Appendix 1B: Environmental Impact Assessment Scoping Opinion

SCOPING OPINION:

Proposed VPI Immingham OCGT

Case Reference: EN010097

Drawing Title  
**FIGURE 6.1: AIR QUALITY STUDY AREA AND RECEPTOR LOCATIONS**

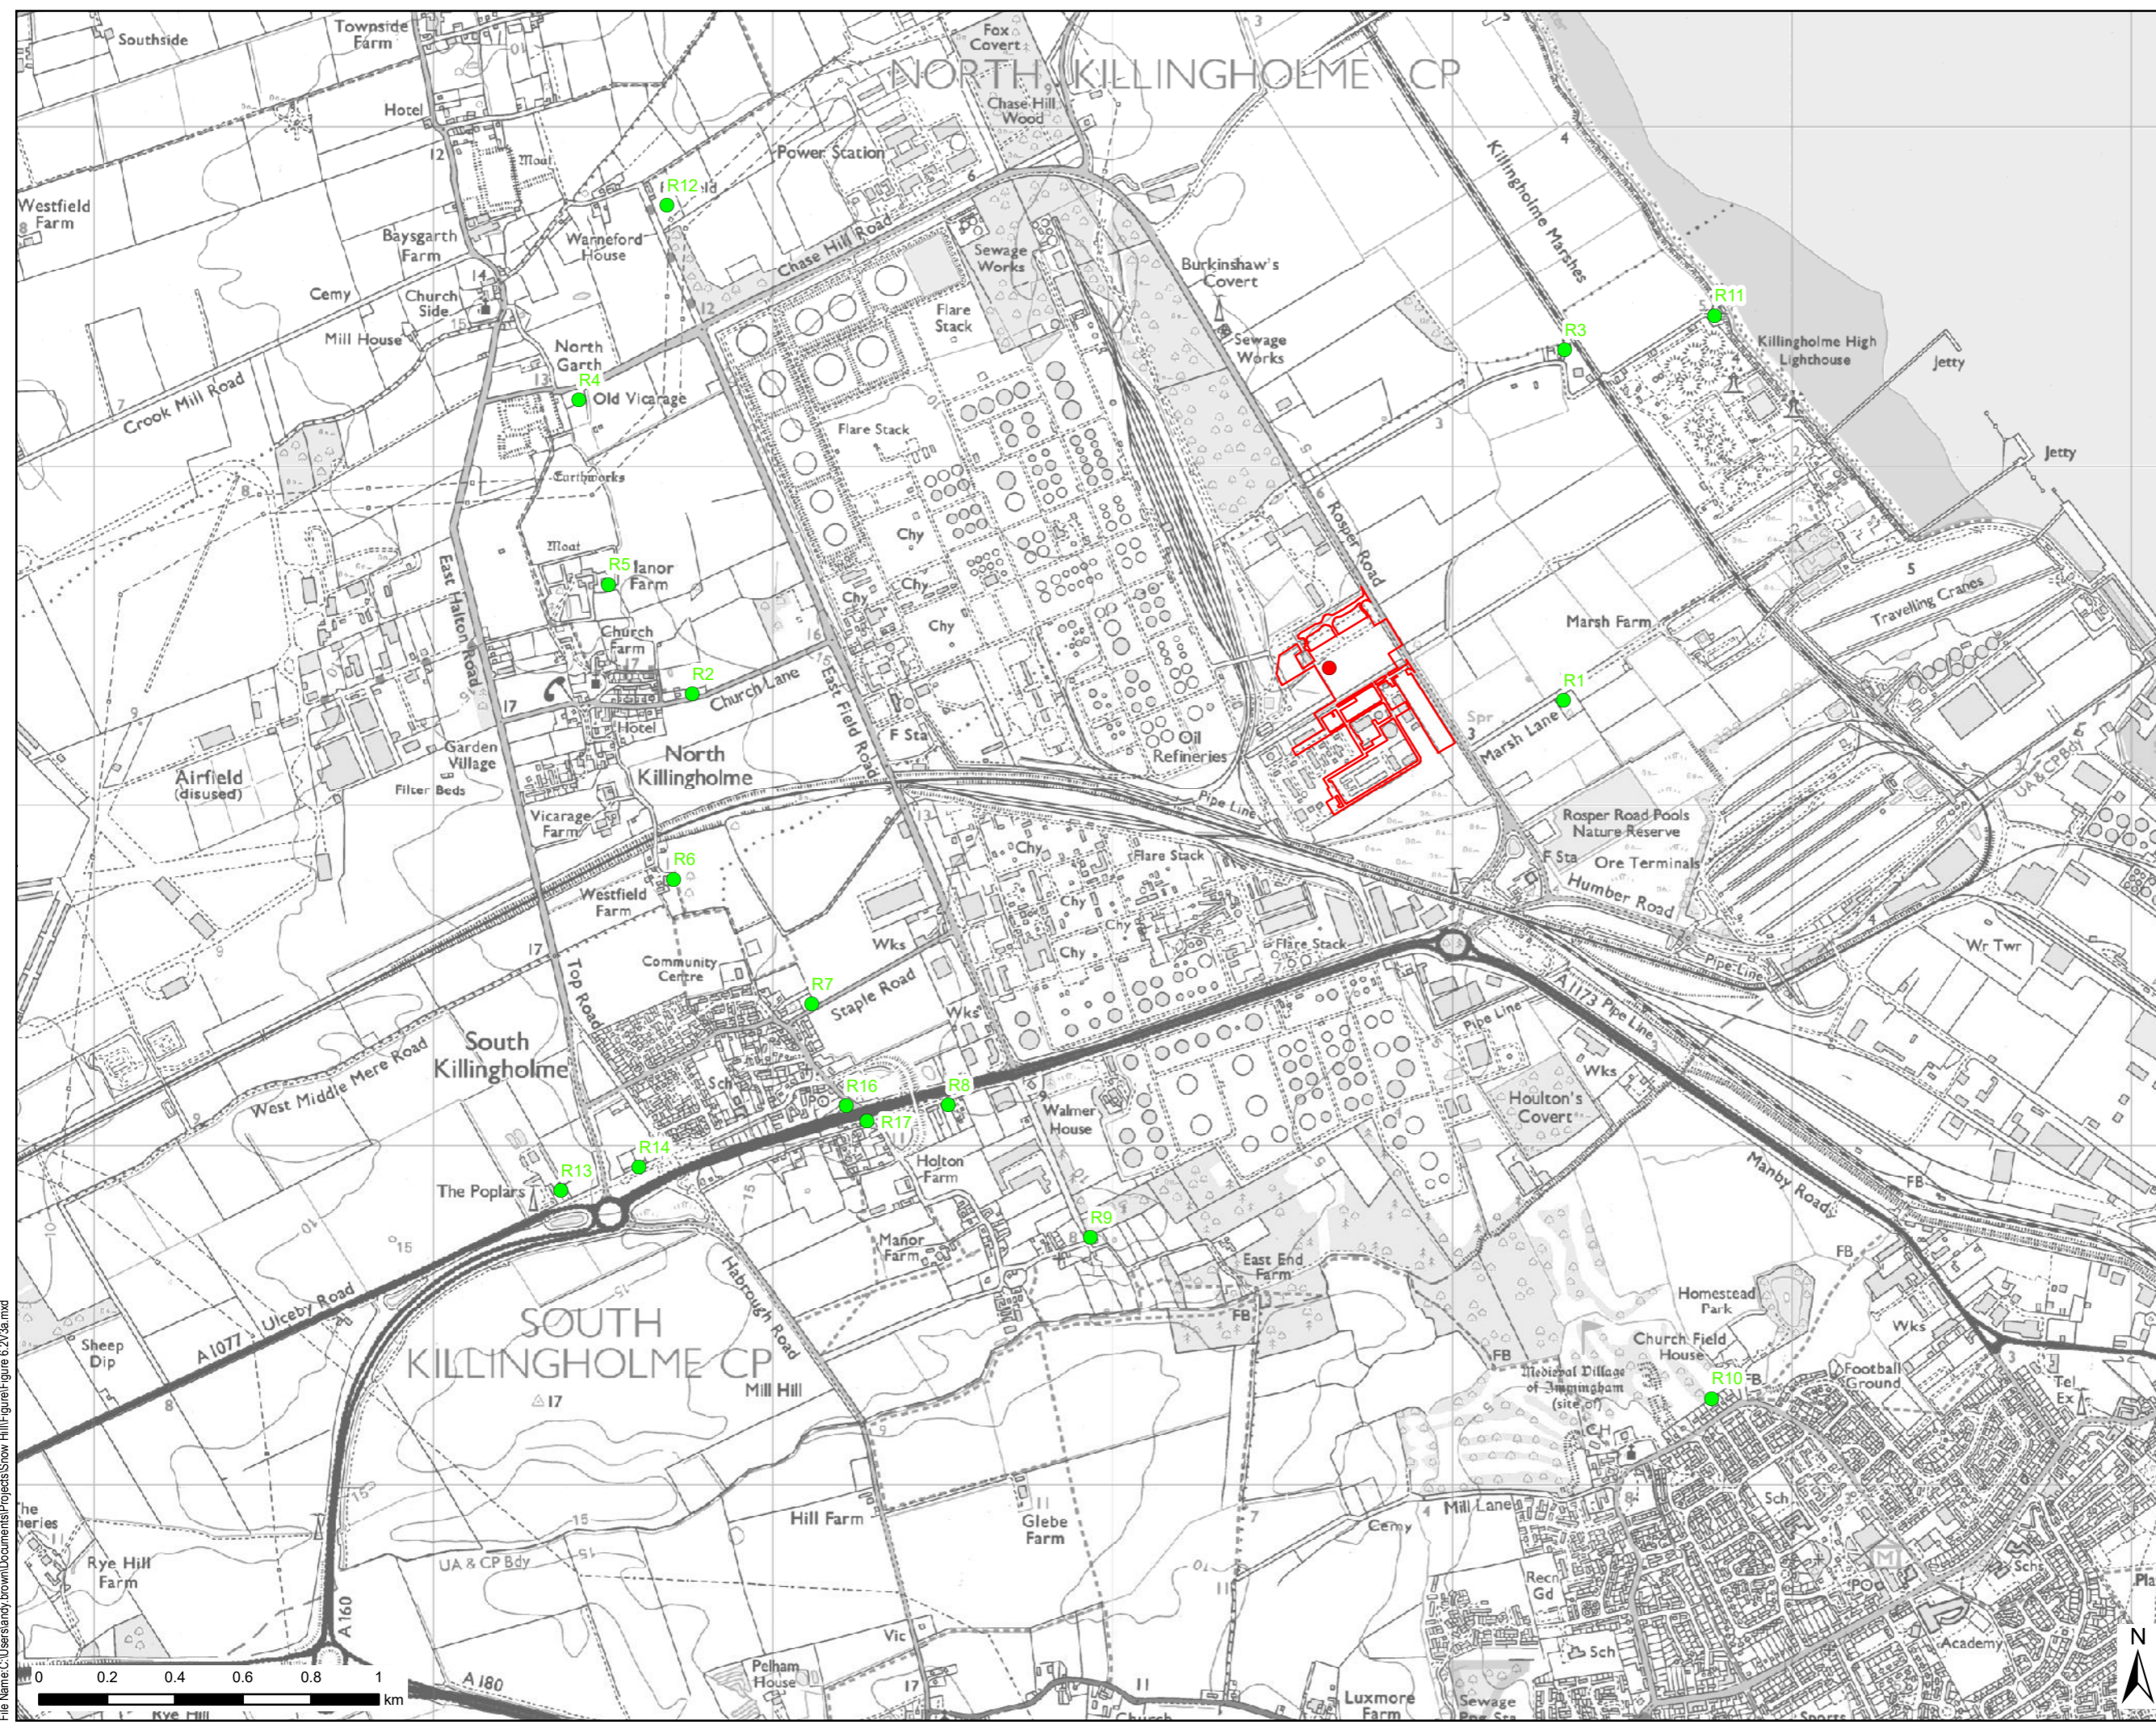
| ID | Para | Other points | Inspectorate's comments |
|----|-------|--------------|--|
| 2 | 6.2.2 | Receptors | The residential receptors that will be assessed are listed in paragraph 2.3 of the Scoping Report. The aspect chapter has not provided justification for why these receptors have been chosen or the precise location for each of the receptors. The methodology used to determine the receptors as well as a concise description of their locations should be included within the ES. For greater clarity the Applicant may consider presenting the receptors on a figure |
